Re : proposed development at 70a Tarrant St. Arundel BN18 9DN .

Ref : AB/118/20/PL

Date : 9 December 2020

Ground Floor - Proposed

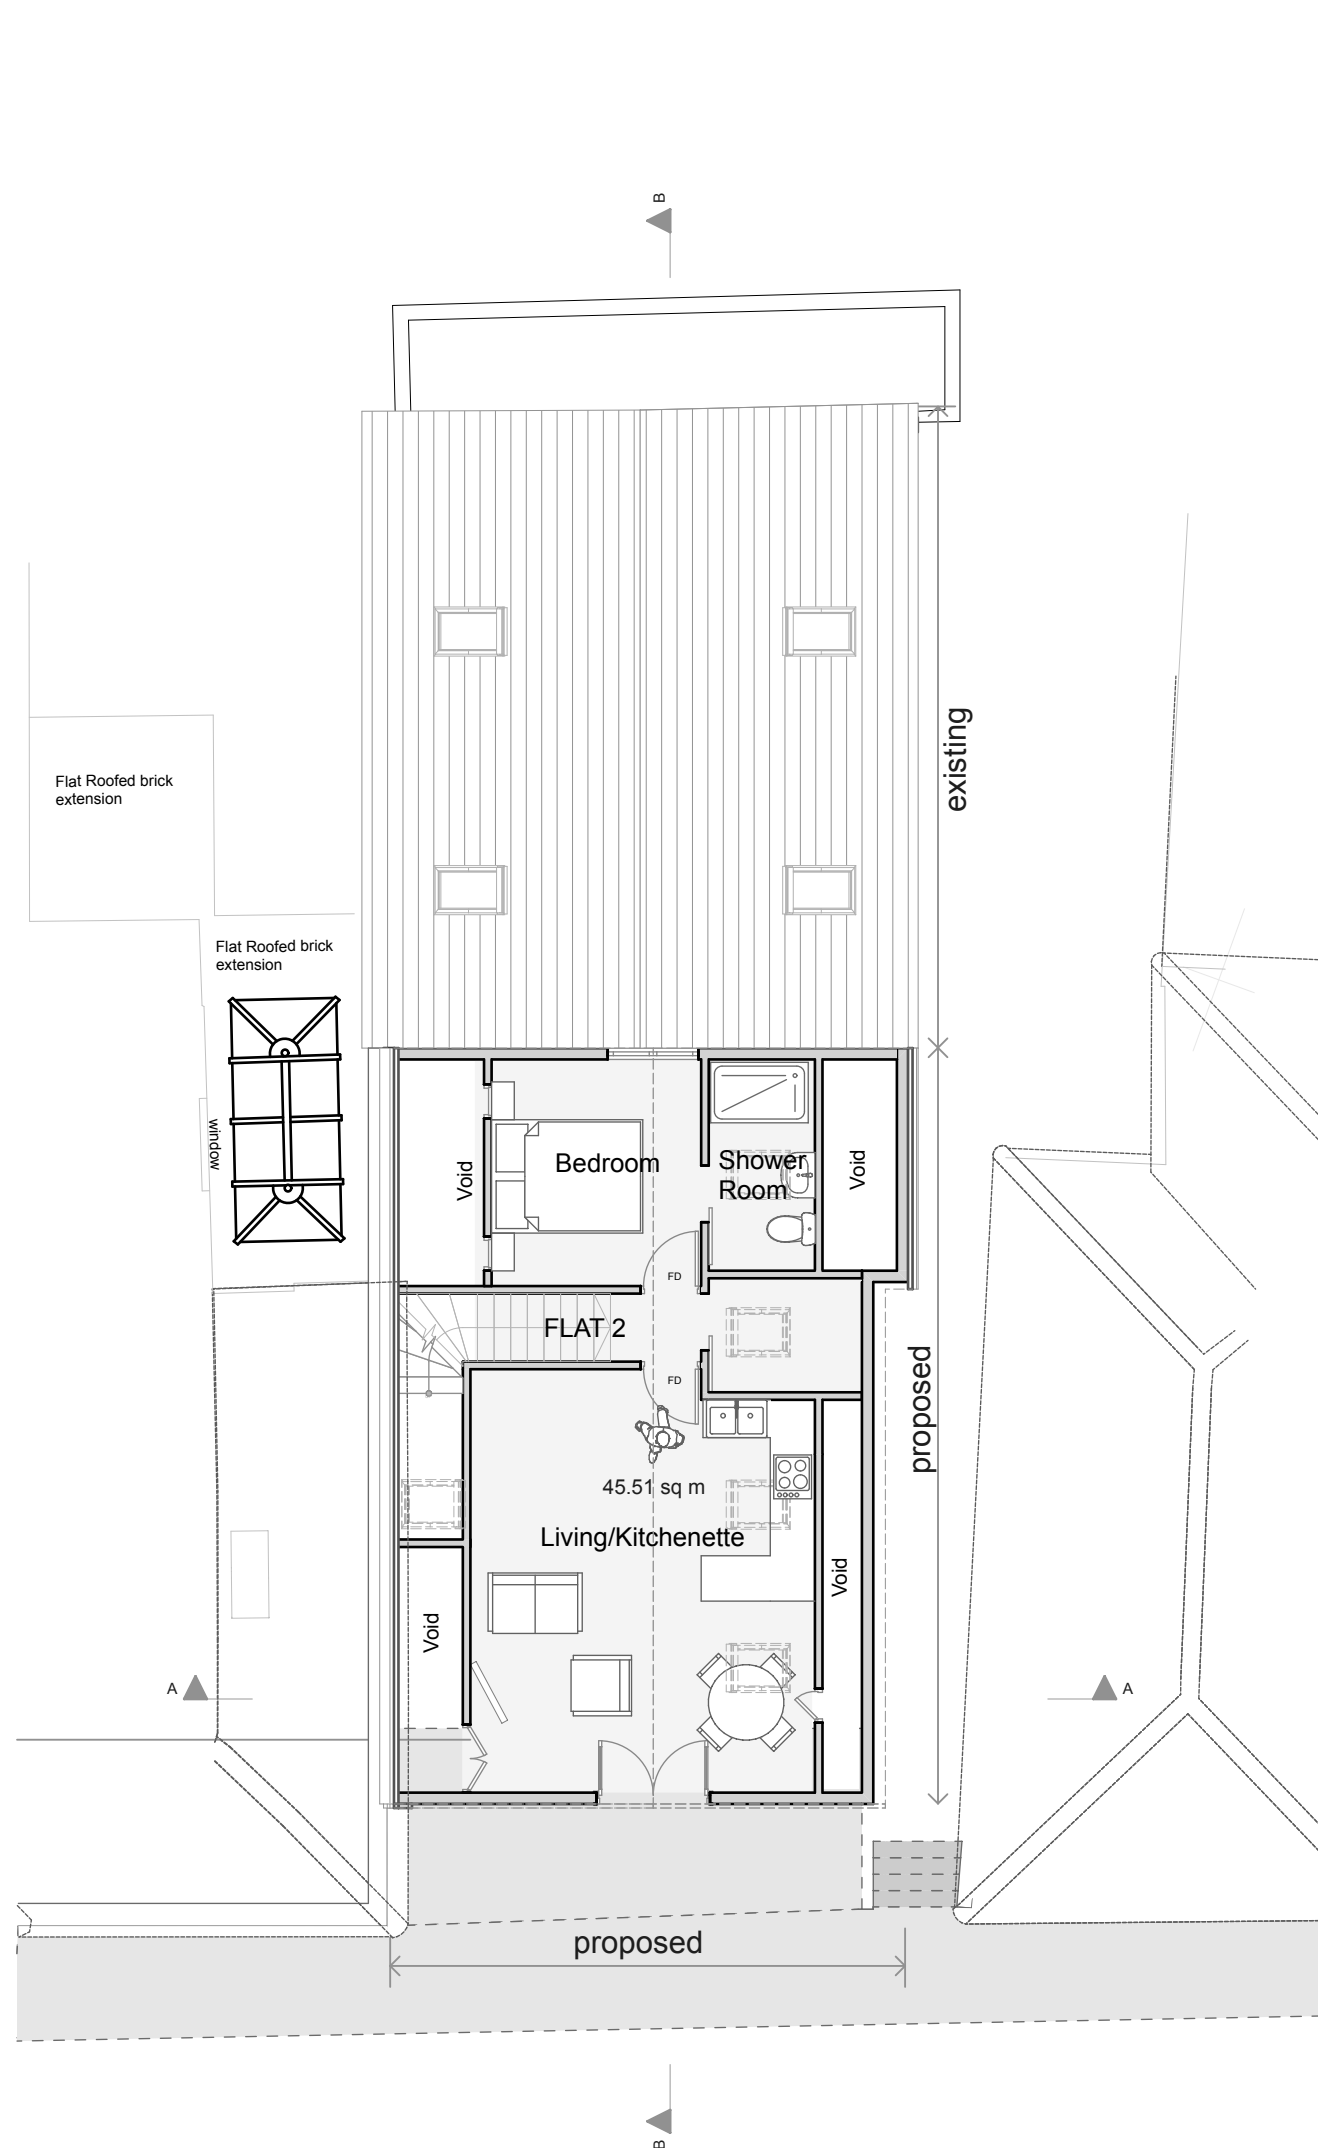
I note that the 1/100 plans are without any dimensions or datum levels with a bench mark, needed to accurately confirm the sensitive physical bulk and height and position of overlooking windows into 64 Tarrant st, of the proposed development which will cause serious loss of light to the flank wall windows being the two at first floor level and an even greater loss of the already shrouded light to the more sensitive ground floor window which gives light to the sitting room.

North Elevation - Proposed

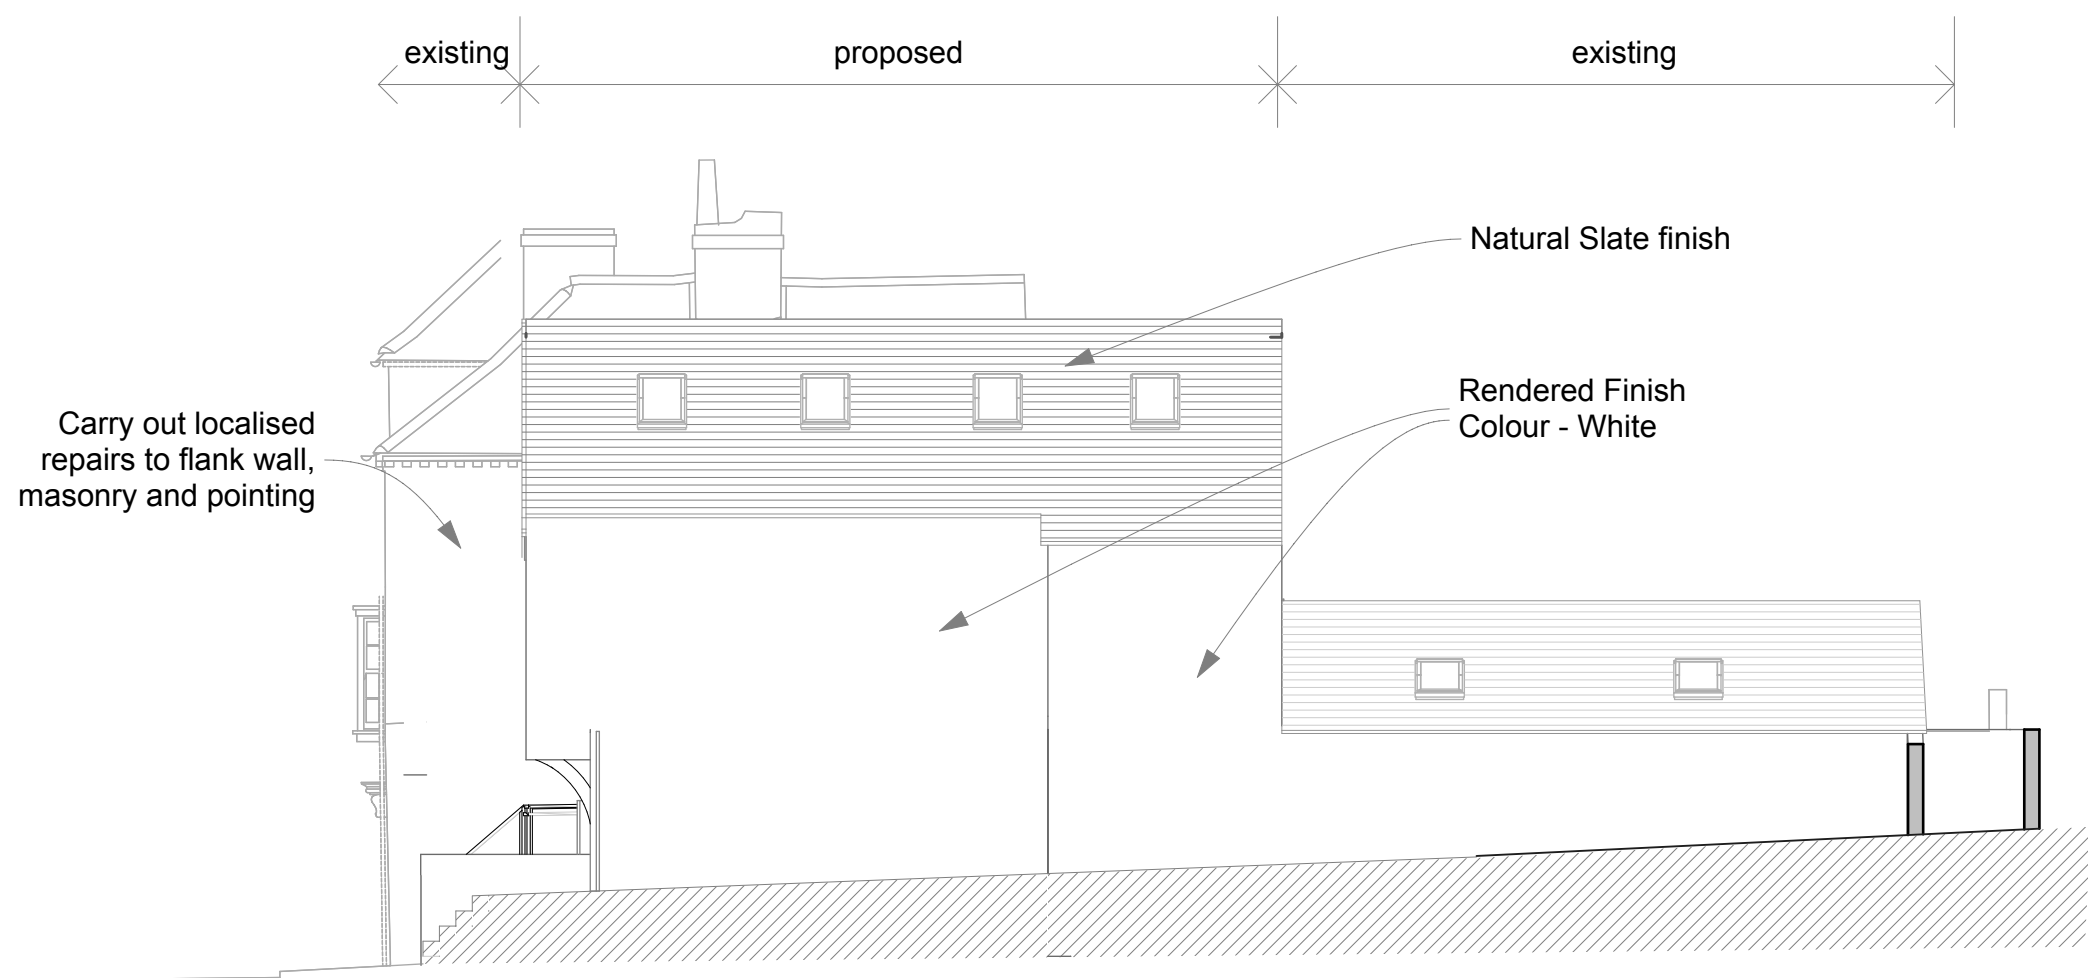
The proposed development extends back too far, 12 feet past the north end of both 64 and 70 causing invasion and **loss of privacy , overlooking and overshadowing** . The three windows in the north gable of the development look straight into our properties and gardens causing total loss of privacy by overlooking.

ing permission for less footage in the 2 storey extension when in fact he is seeking more and therefore he is not following the previous planning permission which he claims sets a precedent . In the 2007 application there were no windows in the north gable end. In the current application there are three - all of them overlooking. There are no dimensions in any of the elevations. The skylights in the proposed development all look into the windows on the flank wall of 64.
